RTA Reference: RDC 10M2551-SYD10/01055  
Contact: Angela Malloch  
Telephone: 8849 2041

### **ROYAL REHABILITATION CENTRE, RYDE**

Reference is made to your correspondence dated 12 November 2010, requesting the RTA to review a proposal for the installation of traffic control signals for the abovementioned development.

NOTE: CONCEPT INTERSECTION PLAN  
- SIGNALISED ACCESS EAST OF IRVINE  
CRESCENT IS SUBJECT TO RTA APPROVAL

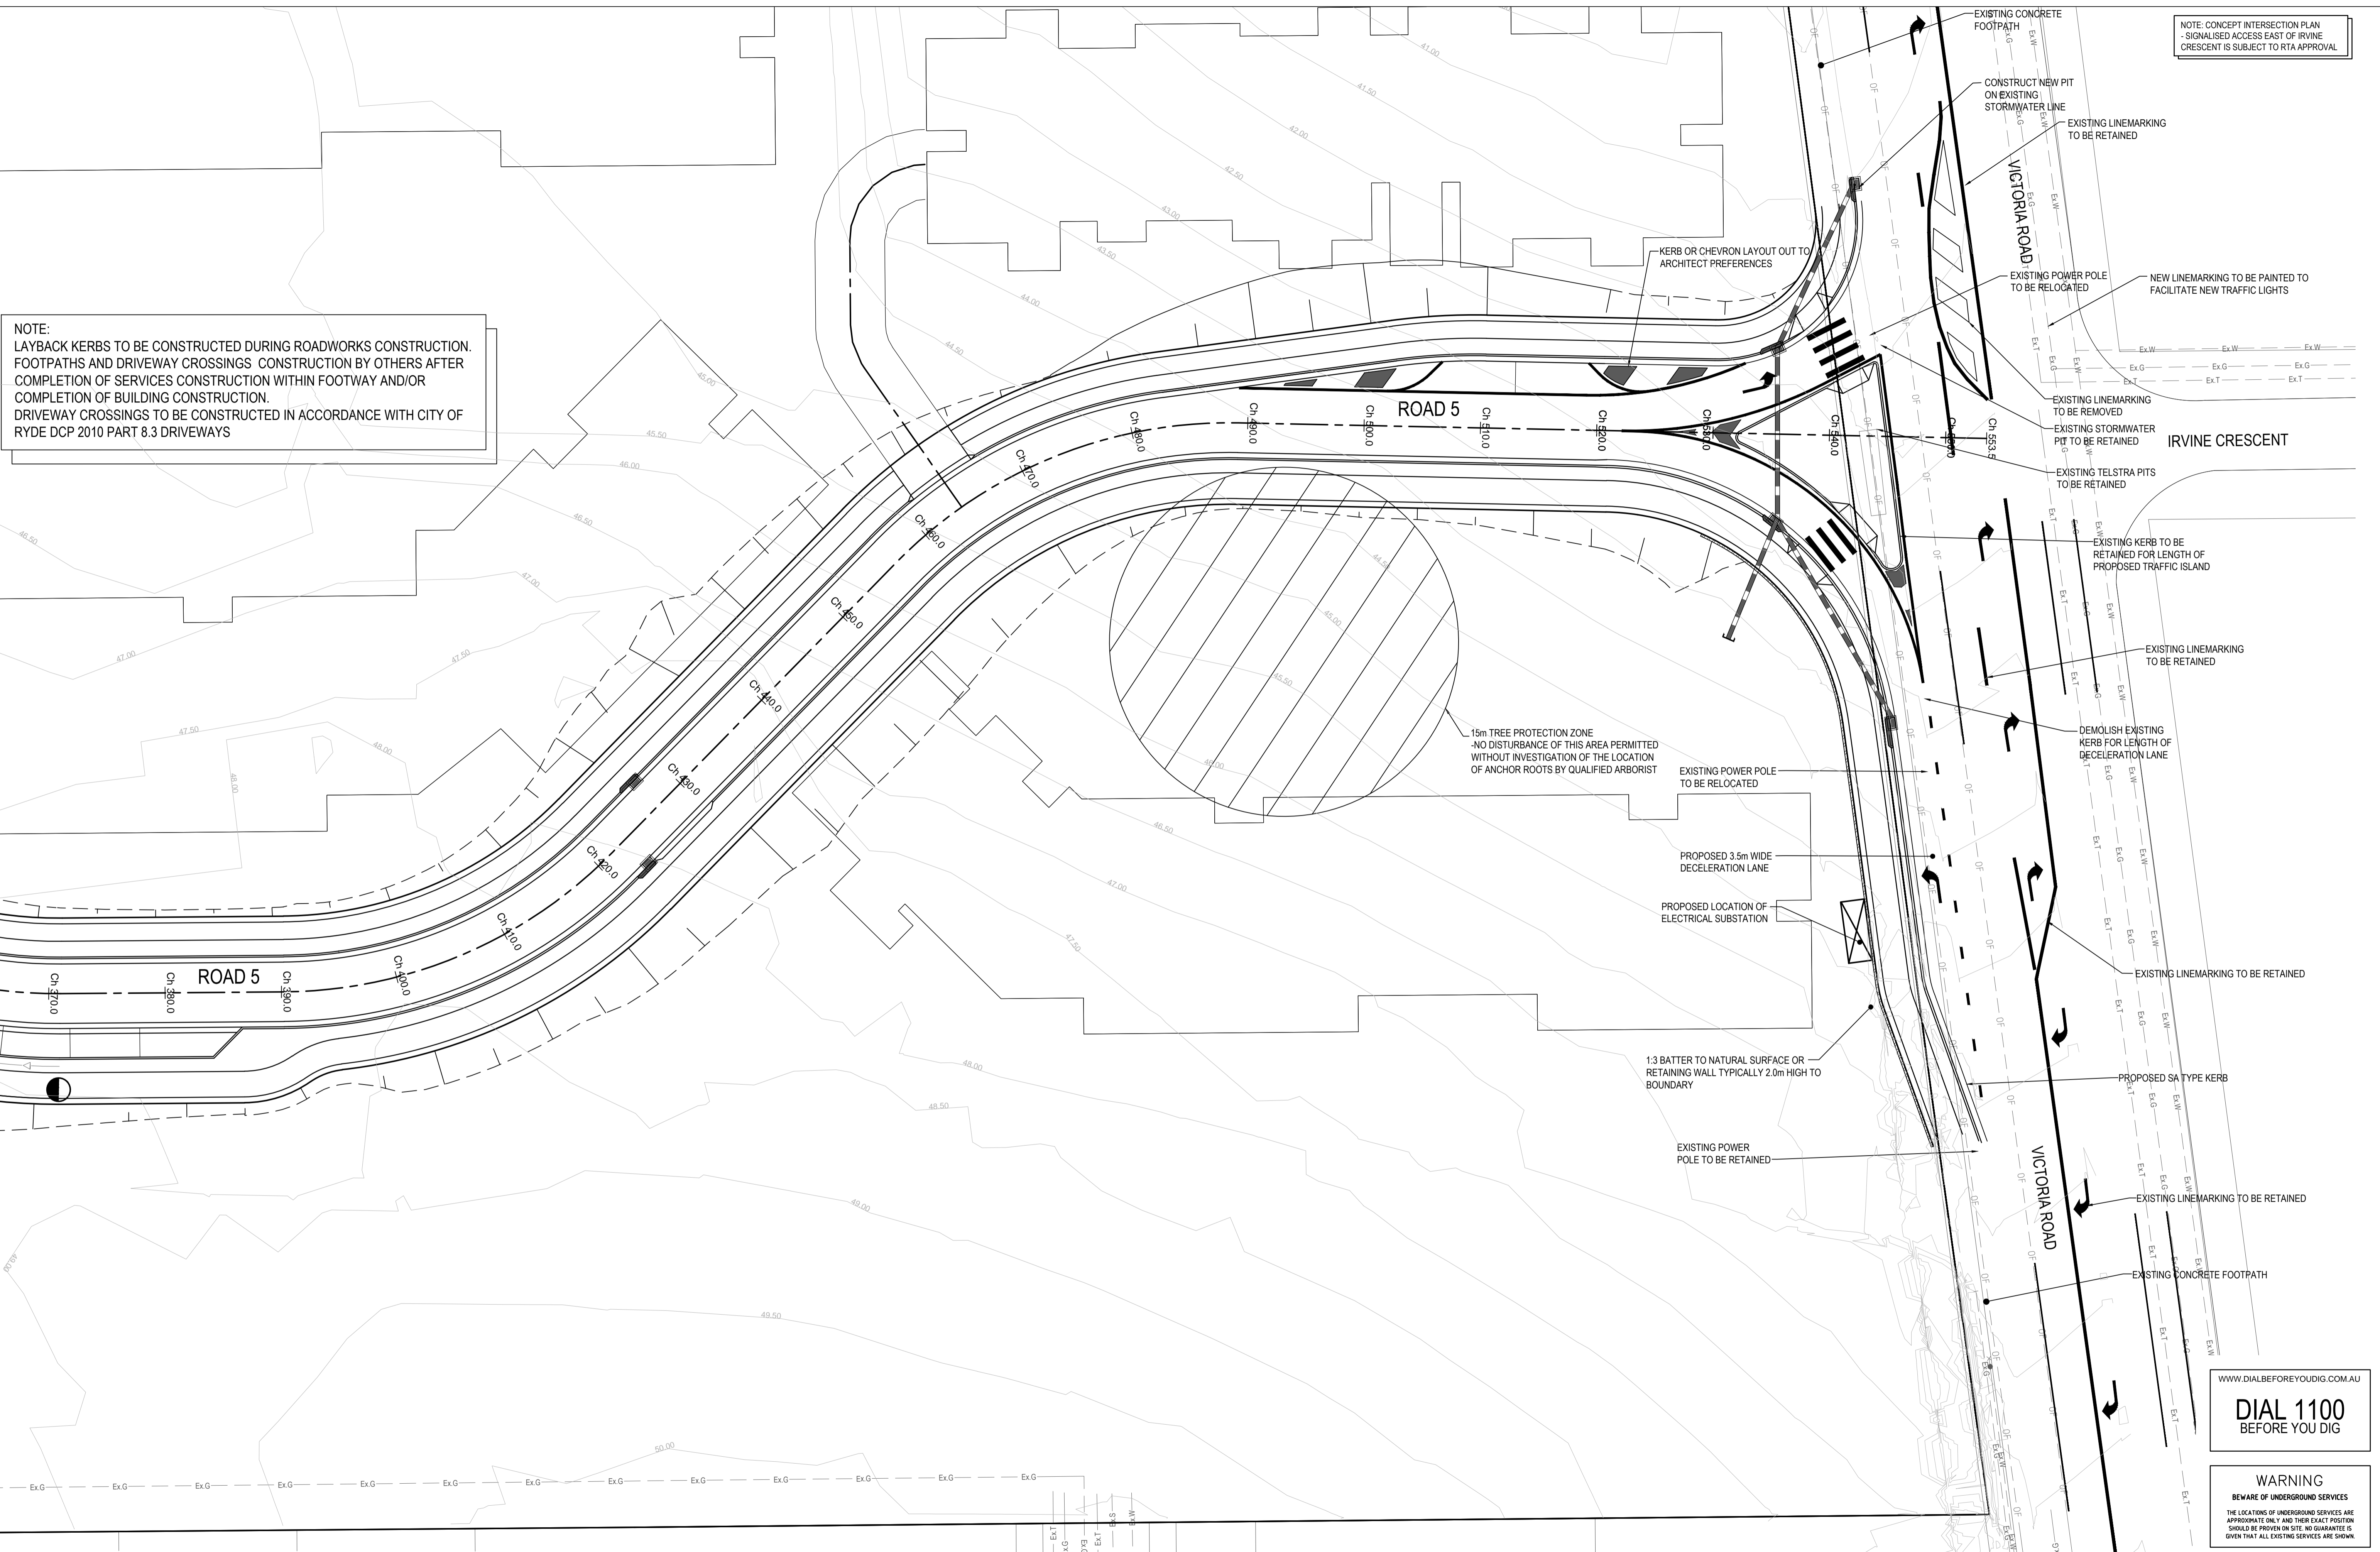
The RTA has previously provided advice to representations from the applicant, Ryde Council and Members of Parliament regarding access to this site. These representations have indicated that full intersection control via signals may have a detrimental impact on the operation of traffic flow along Victoria Road as well as creating a potential accident site due to the location being on a significant down grade through a sweeping right hand turn (eastbound), which under certain conditions (ie: wet weather) could see a car trying to stop at the signals, lose control and mount the footpath with potentially fatal consequences.

The RTA maintains its position and does not support traffic control signals in the proposed location on Victoria Road near Irvine Crescent.

The RTA has previously granted concurrence to the proposed left in/left out access arrangement subject to a deceleration lane being constructed for the left in movement. These access arrangements are still supported by the RTA.
